Subject: Zentz Short Plat, SP-13-00003

The Kittitas County Community Development Services Department has determined that the Zentz Short Plat (SP-13-00003) is a complete application and hereby grants *conditional preliminary approval* subject to the following conditions:

SHORT PLAT PREPARED FOR TERESA ZENTZ A PORTION OF THE NW 1/4 OF SECTION 20, TOWNSHIP 18 NORTH, RANGE 18 EAST, W.M.		
KITTITAS COUNTY DWN BY DLP/GW	DATE 03/2013	JOB NO. 13017
CHKD BY DLP	SCALE 1" = 100'	SHEET 1 OF 2

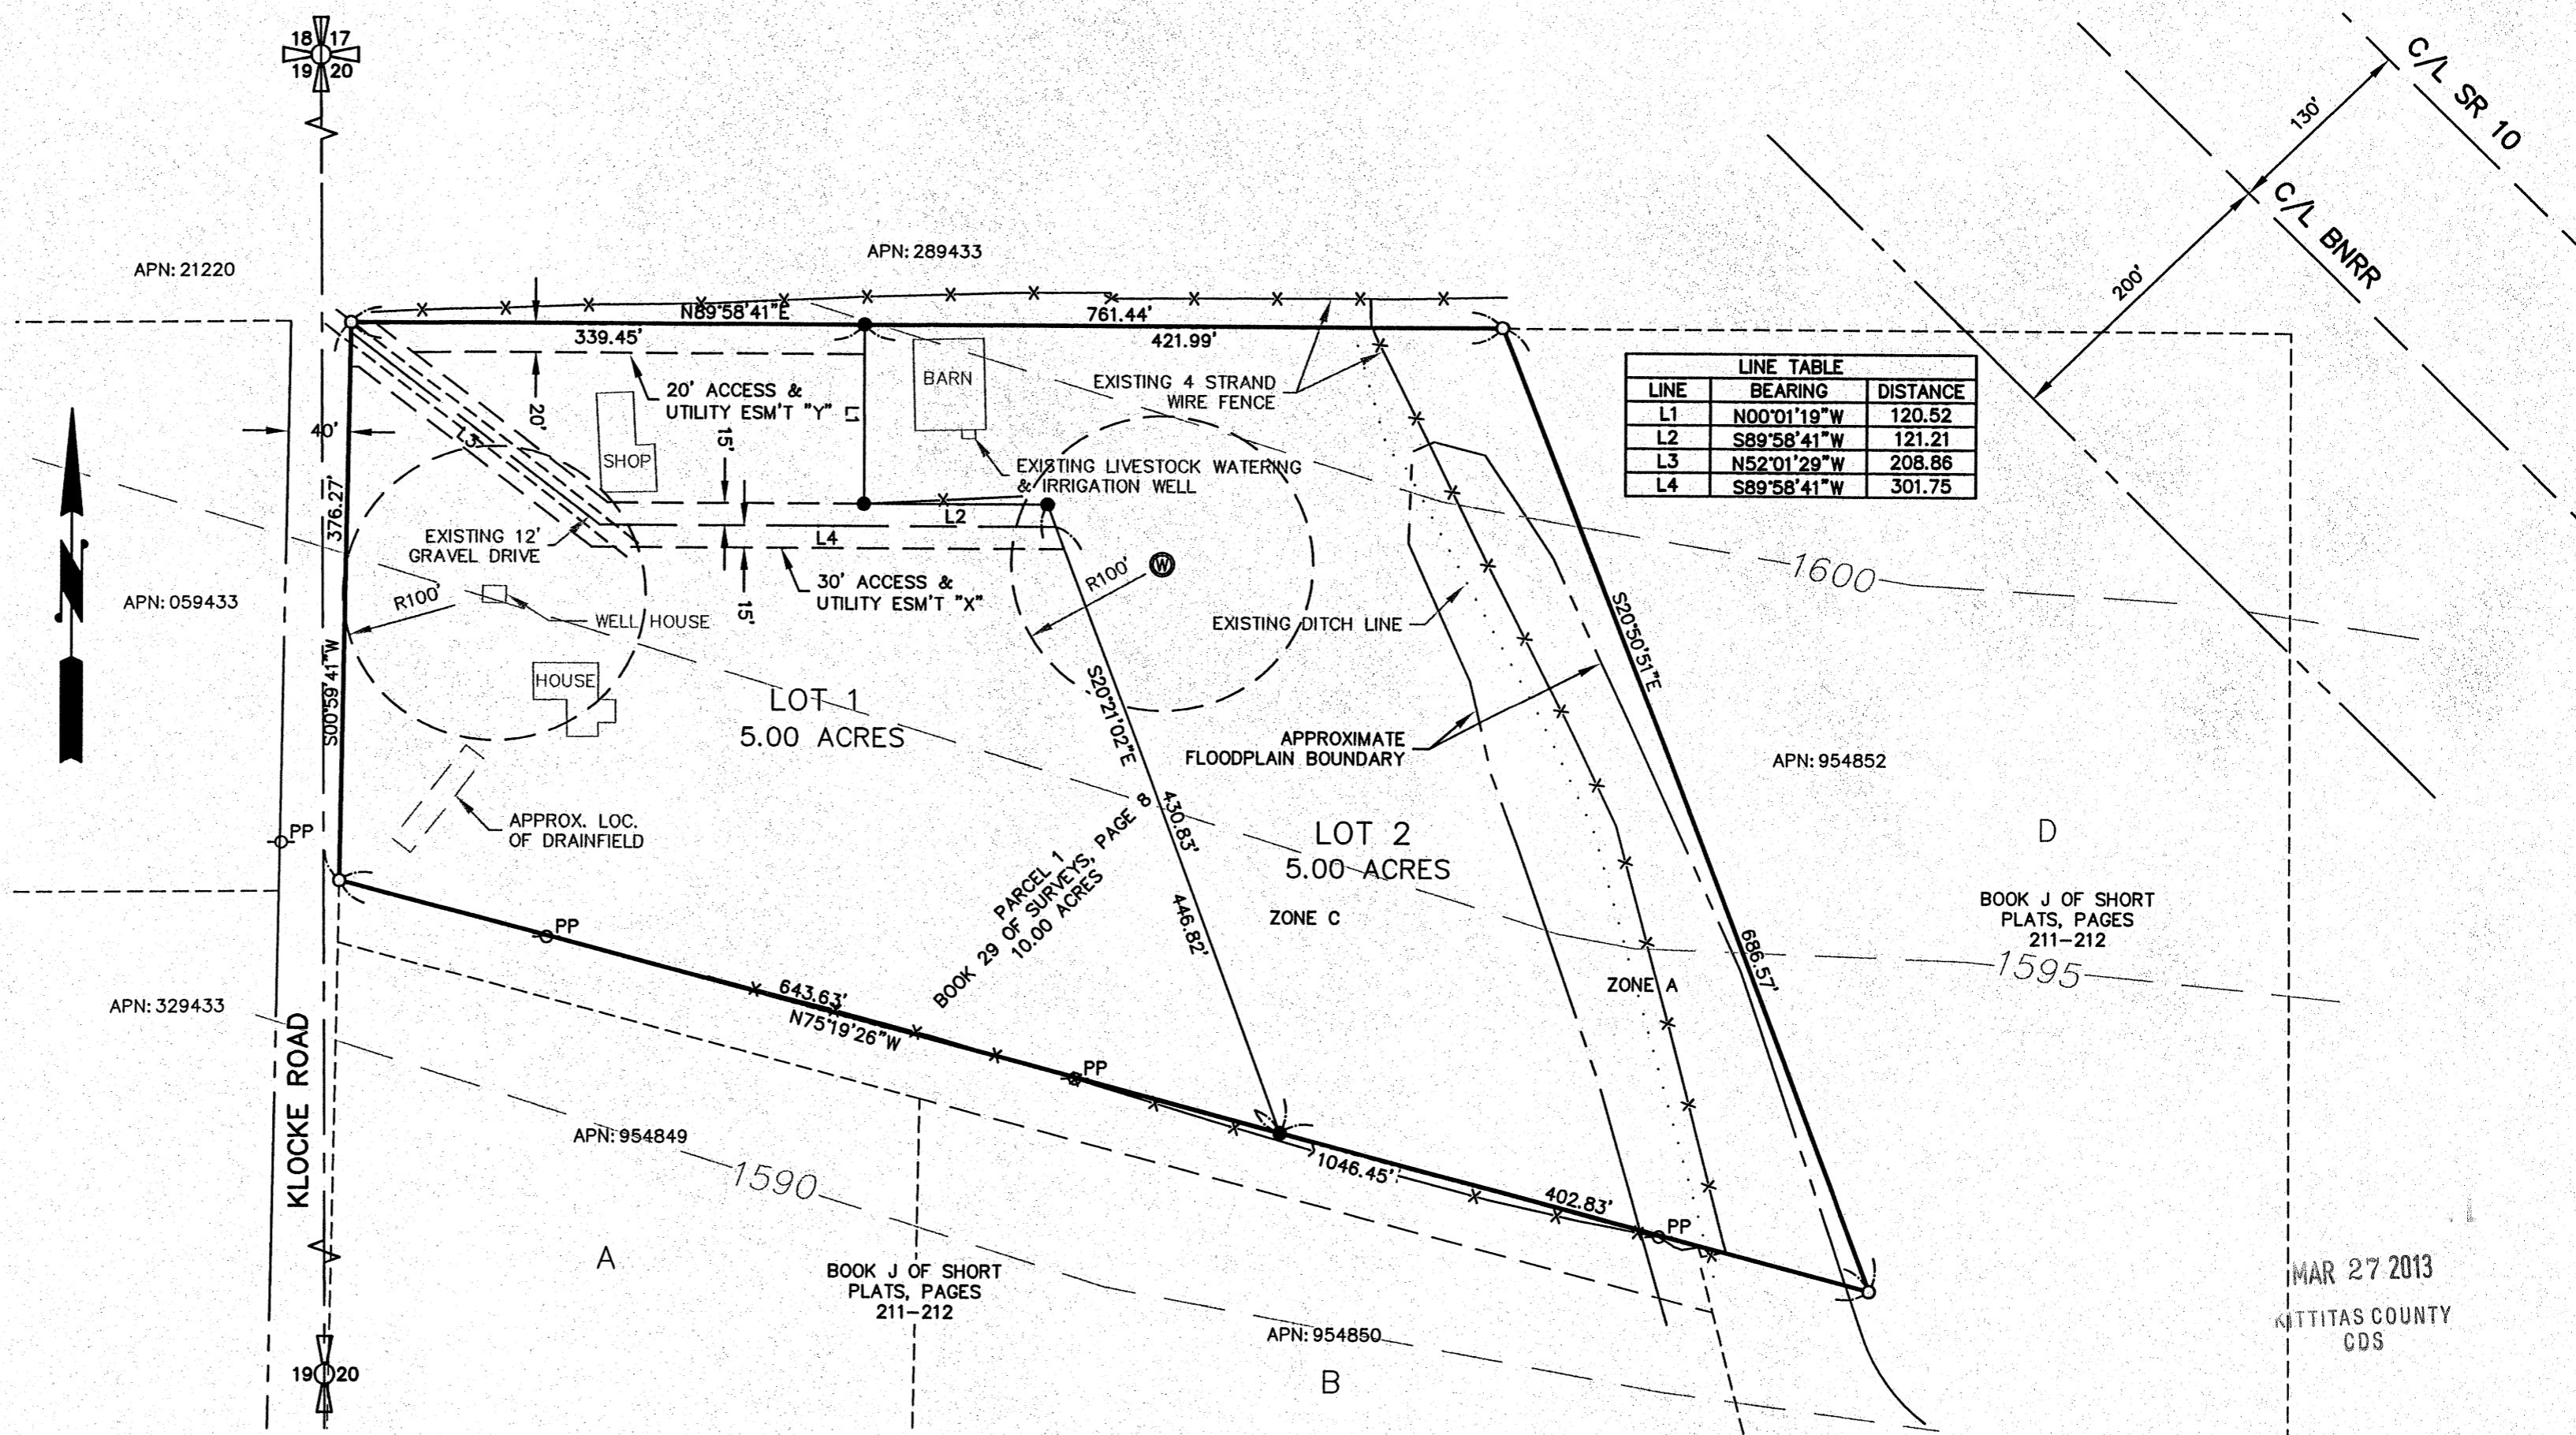
- 1) Both sheets of the final mylars shall reflect short plat number SP-13-00003 and an accurate legal description shall be shown on the face of the final plat.

- 5) A statement regarding the contemplated sewage disposal, water supply, and drainage improvements for the proposed subdivision shall be reflected on the final mylars.

- 9) Lot 1 of the Zentz Short Plat contains a PUBH wetland within its boundaries. The Final mylars shall reflect the location of this wetland and a statement on the plat shall read as follows: "Future development of lots may require a study by a certified wetland biologist to determine wetland classification and for buffer requirements pursuant to KCC Critical Areas Code."
